Re: Planning Application No 3/2021/0082

I am writing to object to the above planning application. There are numerous grounds for objection. An explanation of the layout of the relevant plots assists in understanding why the proposed development would have an unusually adverse effect on neighbouring properties.

proposed rear  
(NE facing) elevation

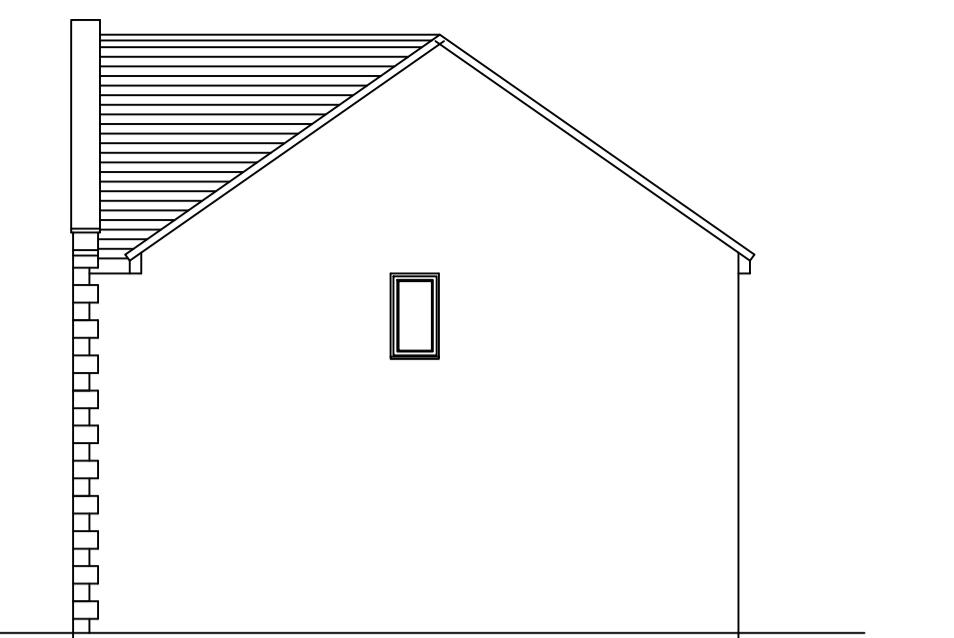
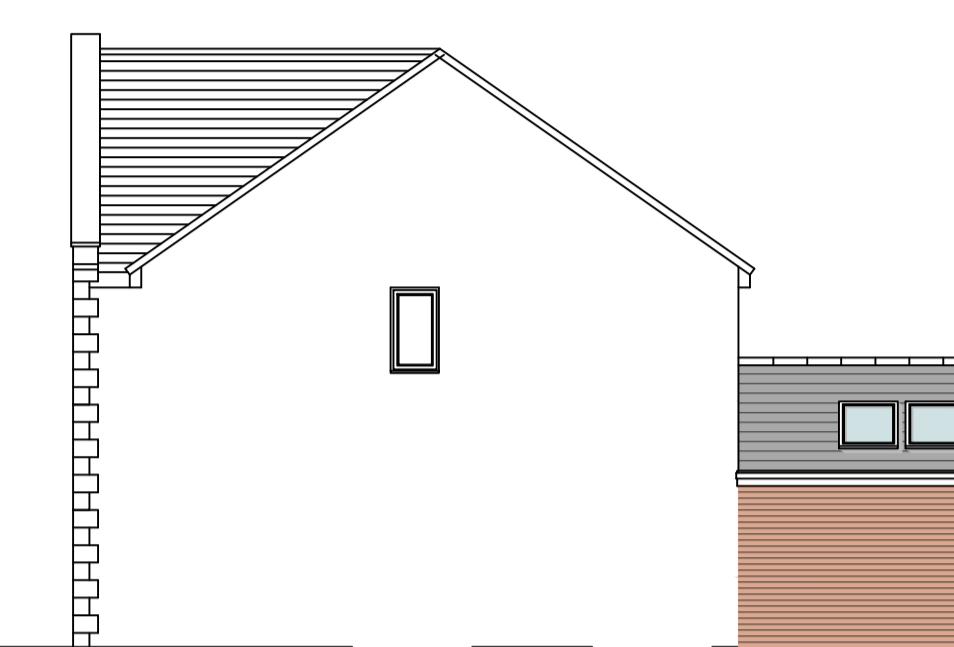
The proposed development is unnecessarily high. It also contains windows that will face the dining kitchens of 1 and 3 and cause a potential loss of privacy. The proposed height and inclusion of windows in the roof are disproportionate particularly as the glass rear of the extension would allow more than enough light to enter the property. In short, the proposed extension is disproportionately high and doesn't need windows in the roof. It will result in a decrease of light into the rear of 1 and 3 in order to allow a large amount of light into 24 which is evidently and obviously overbearing.

proposed site plan (1:500)

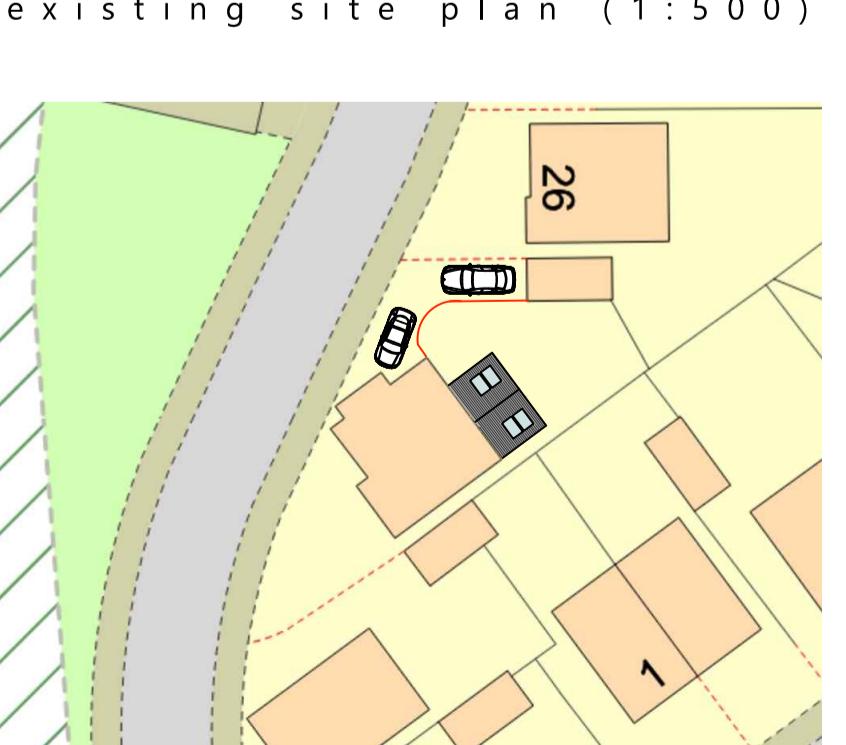
As can be seen from the submitted plans the layout of the plots for 24 Blakewater Road (24), 1 Lune Road (1) and 3 Lune Road (3) are unusual in the regard that 24's garden runs horizontally from the back of the property across the end of 1 and 3 as opposed to the more common arrangement of gardens being 'back to back'. It is this arrangement that makes the proposal inappropriate because the proposed extension has to run across the rear boundary of the gardens of 1 and 3 causing them to be hemmed in. The gardens of 1 and 3 are small which will further increase the adverse effect. I would ask that the planning officer gives particular consideration to this layout.

The impact on 3 will also be considerable as a significant extent of the rear boundary will be hemmed in by the proposed extension. Again this will be overbearing. The submitted plan does not adequately demonstrate the extent of this as it does not show the shed in the garden of 3. That lies behind the garage of 5 Lune Road. That patch of garden is unsuitable for any other use due to the overshadowing from the garage so the impact on 3 is considerably more significant than the plan would suggest.

section through rear extension (1:50)

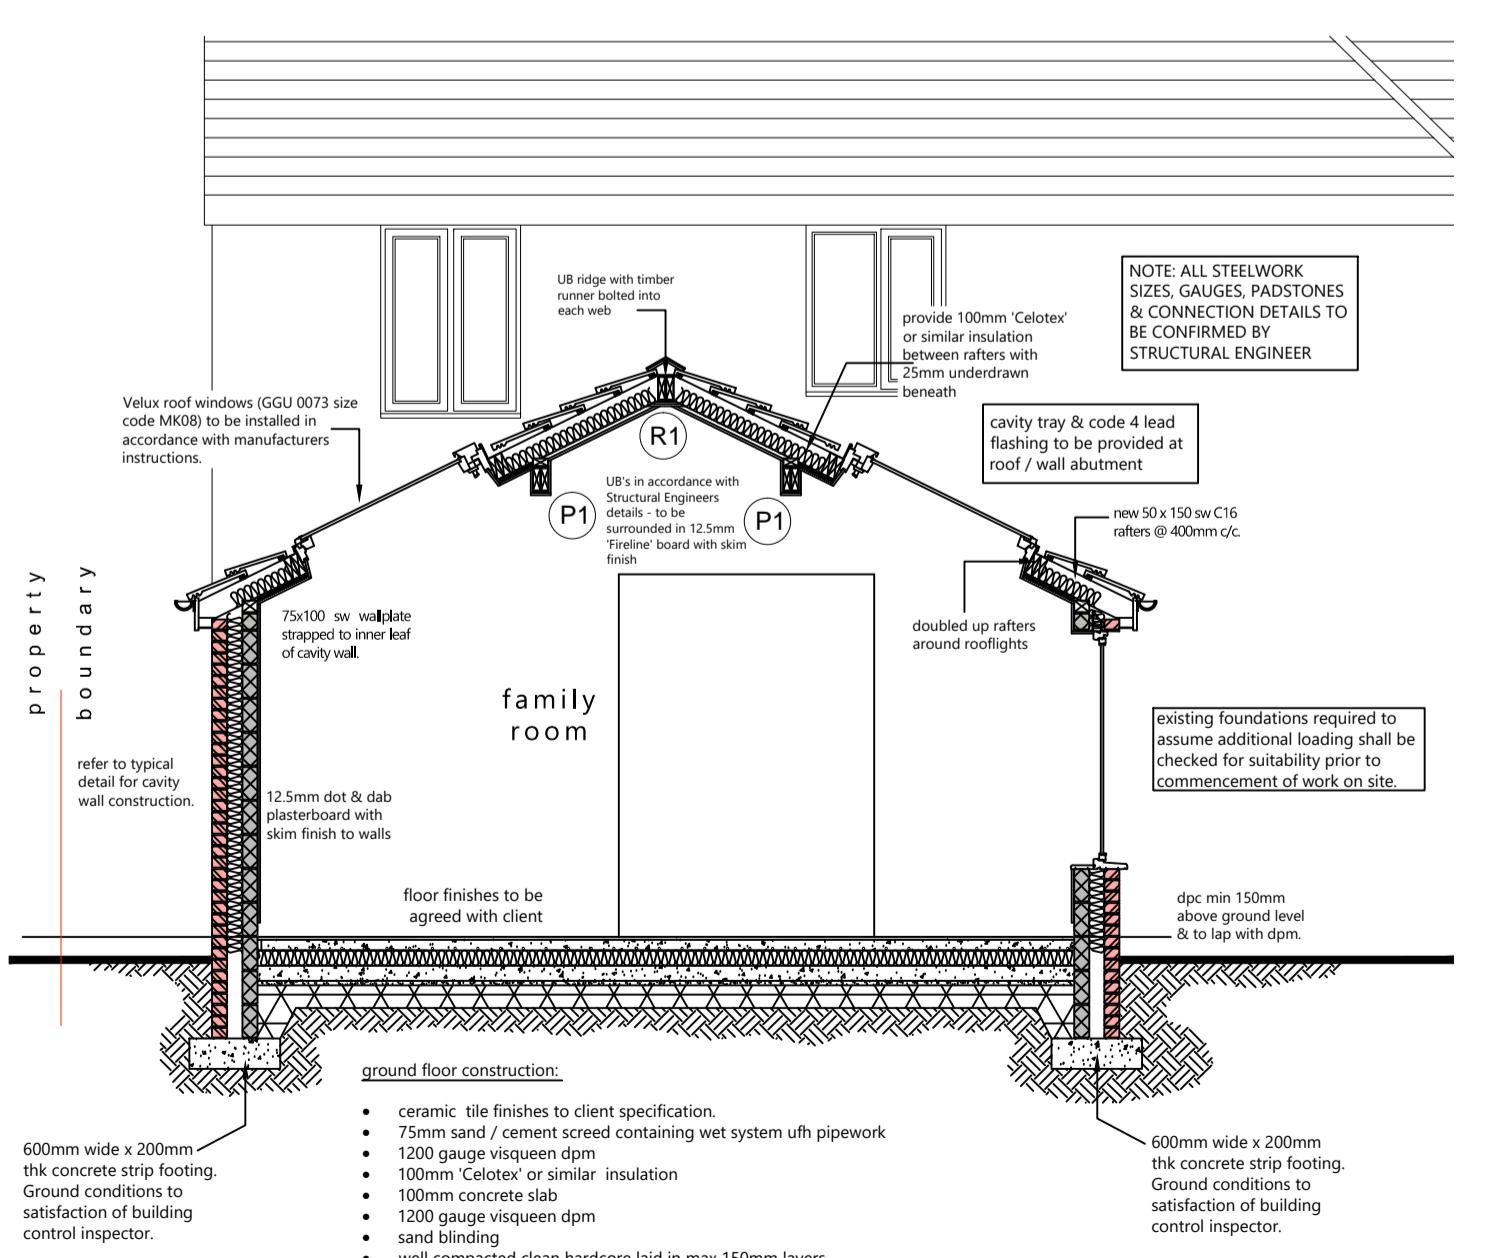
As introduced above the principal objection is the adverse effect the proposed development would have on the occupants of 1 and 3. The scale of the development will cause significant overshadowing and effectively hem in both properties. The layout of the plots (as outlined above) combined with the height of the proposed extension make it inappropriate. The maximum height of the extension is 4 metres which is double the height of the existing boundary. The extension would be so close to the existing boundary to, in effect, make it a new boundary. The height at the join with the existing property is such that it will completely hem in 1 and will be overshadowing to a catastrophic extent. The nature of the existing development with neighbouring garages forming part of the boundaries of 1 and 3 will further exacerbate the overbearing nature of the proposal.
